RE: Staff Review Comments for Level II Preliminary Site Plan

Project Name: Pomeroy Street Construction  
Applicant: Chabad Lubavitch of Maine, Inc.  
Planner: Nell Donaldson

Project ID: 2012-471  
CBL: 193-E-1

VERTICAL GRANITE CURB DETAIL
N.T.S.

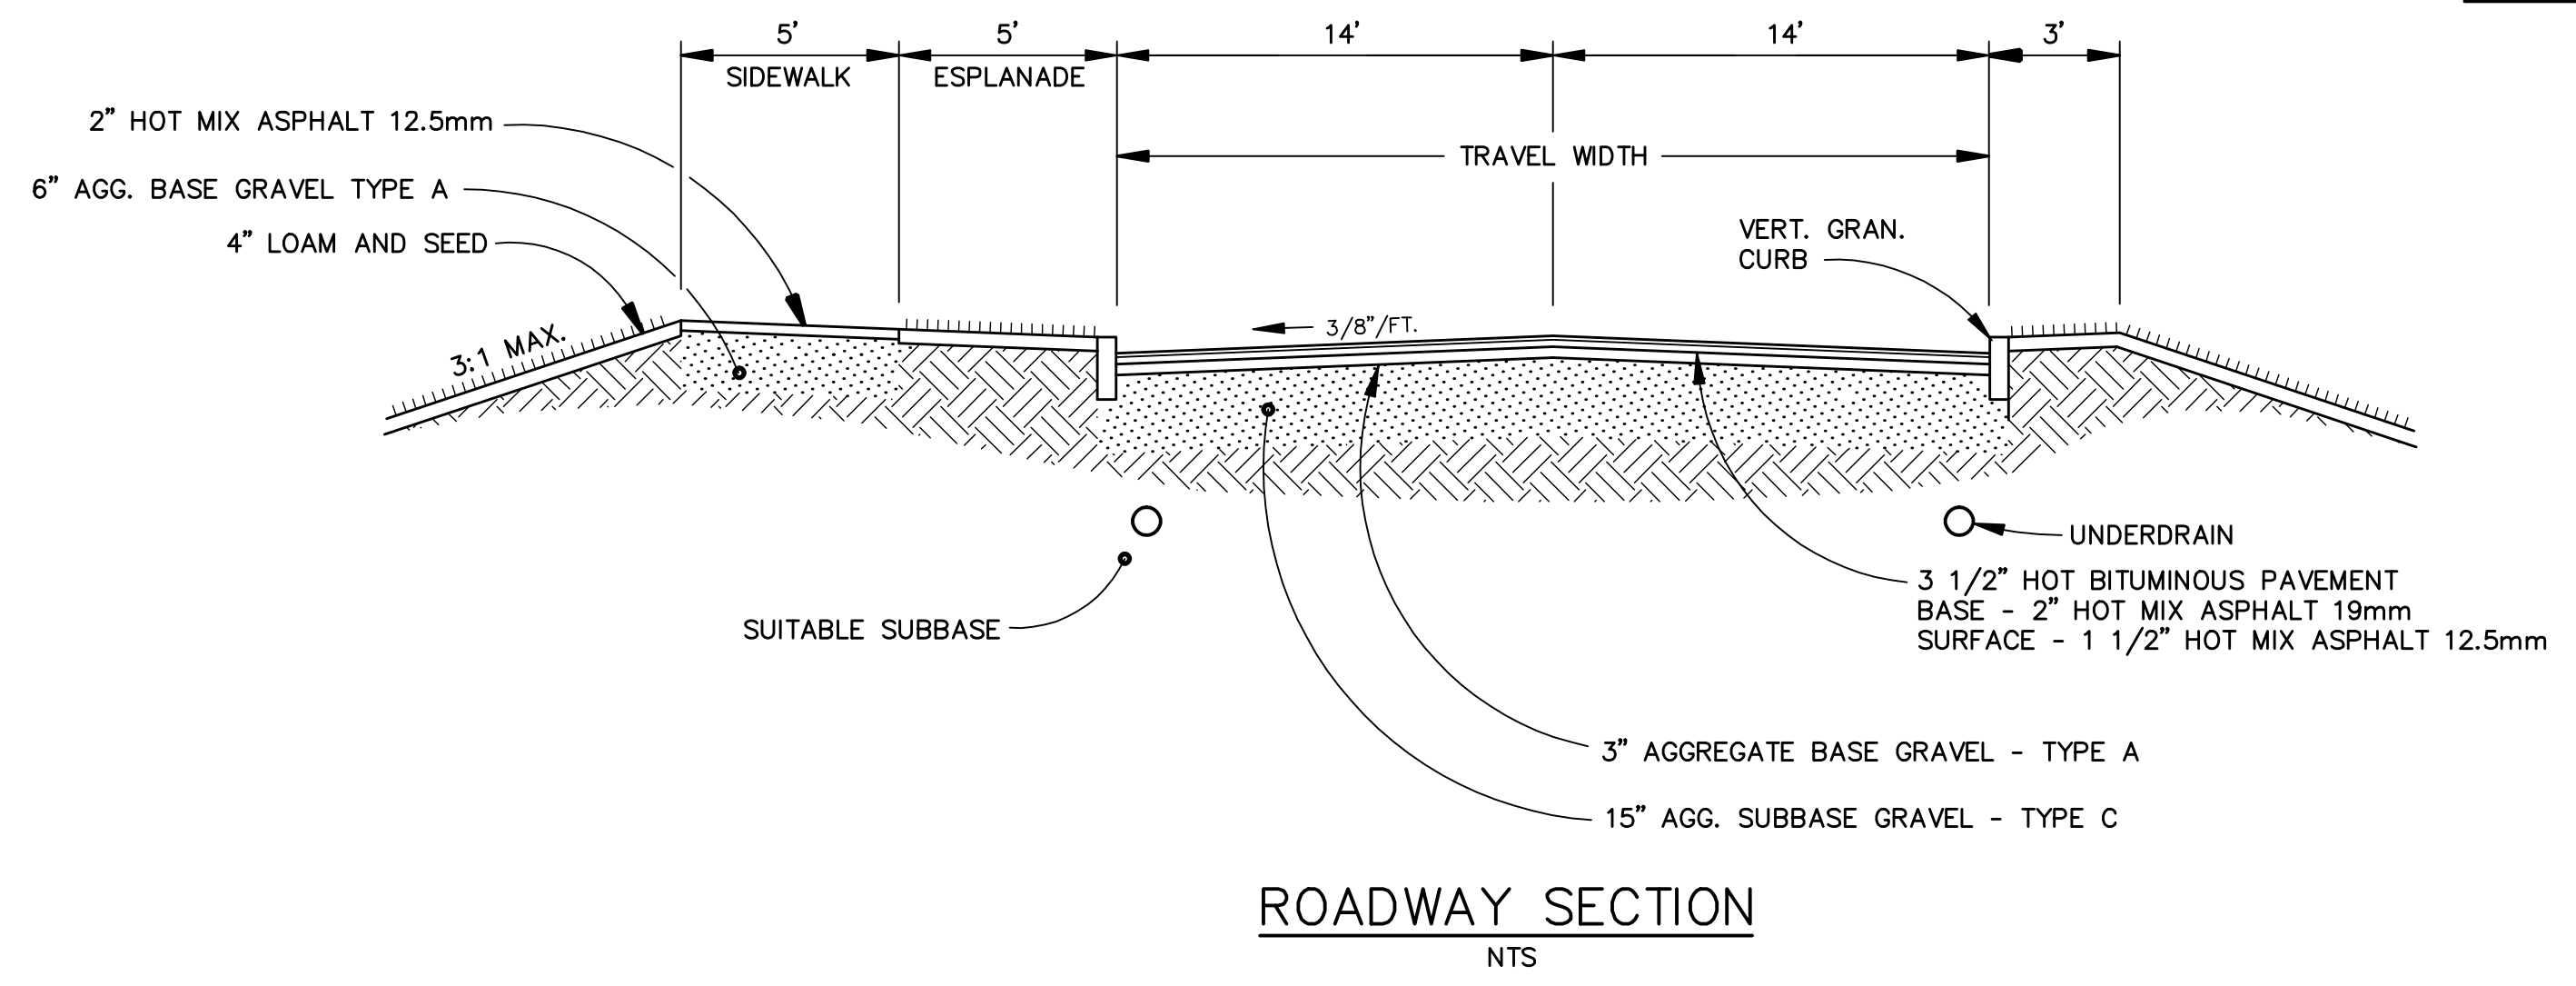
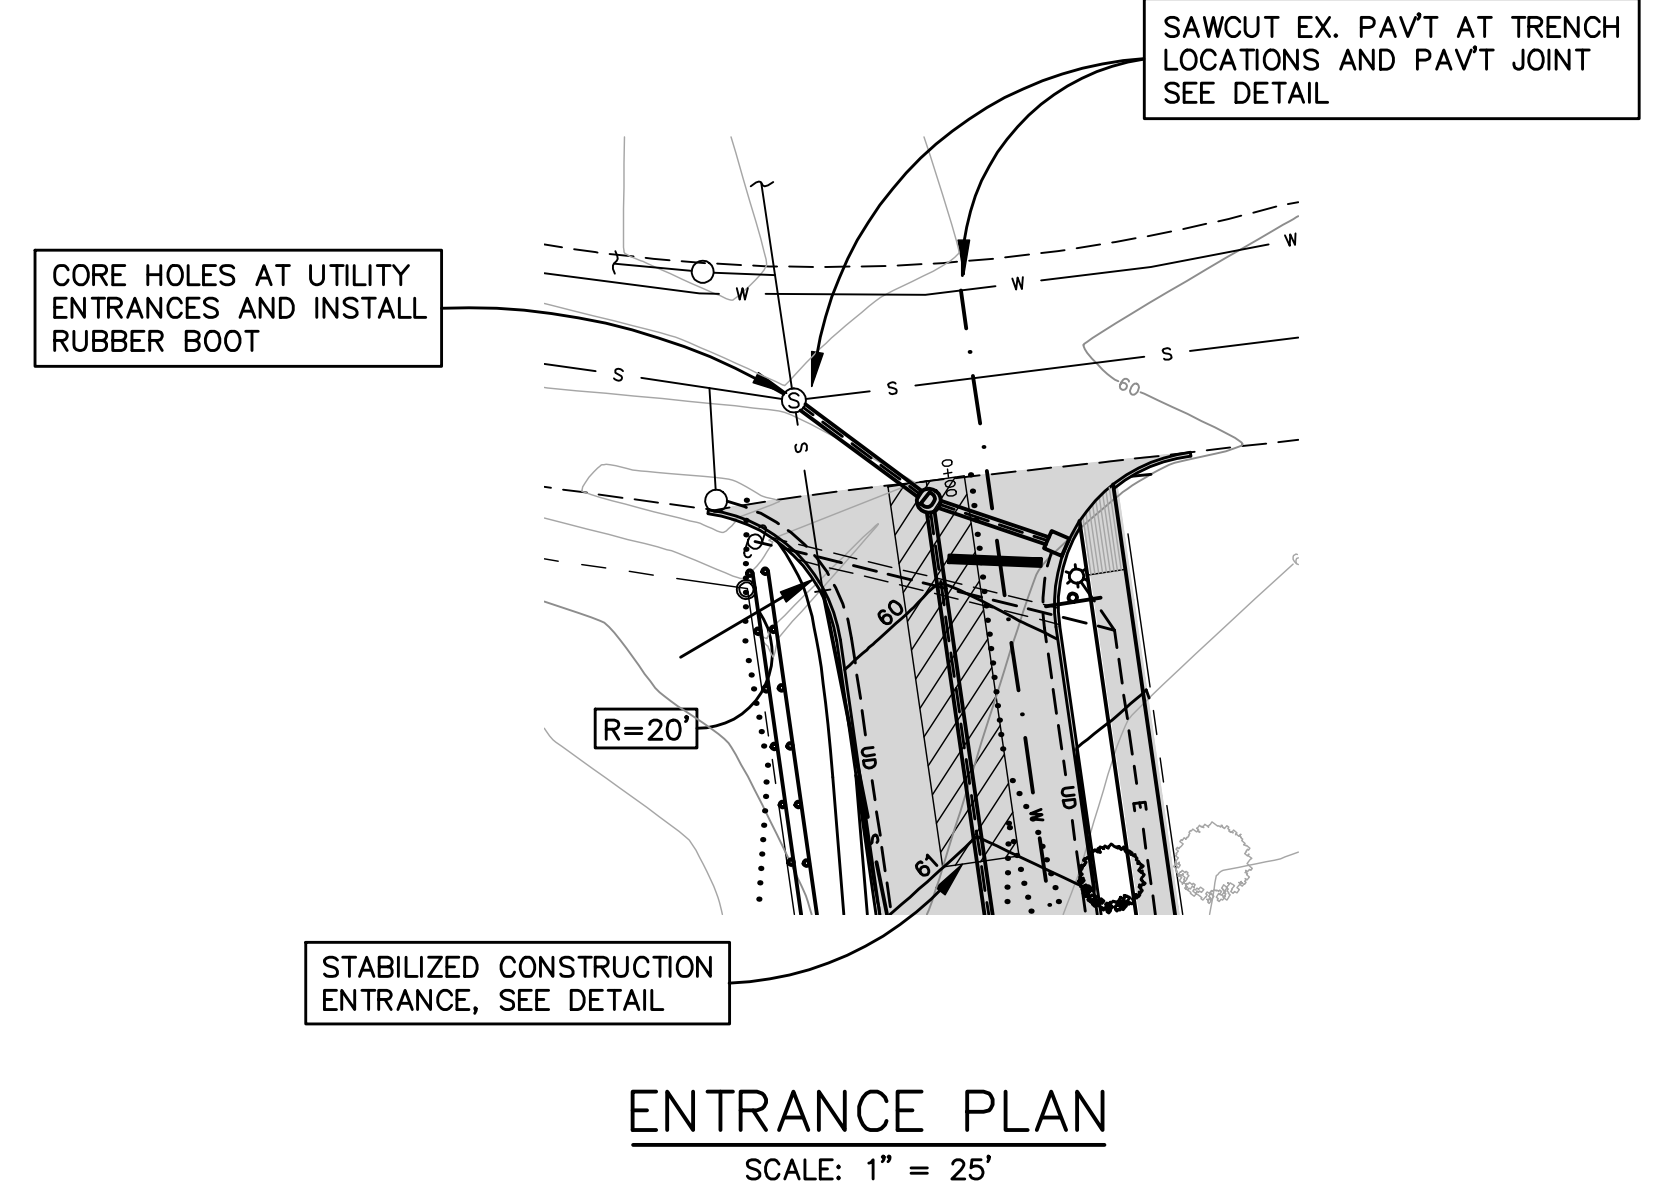
- In accordance with Section 1 of the *City of Portland Technical Manual*:
  - a) The aggregate base course for a bituminous sidewalk should be 10” of Type B gravel per Figure I-12.
  - b) Vertical granite curbing and terminal curb details should be per Figure I-16.
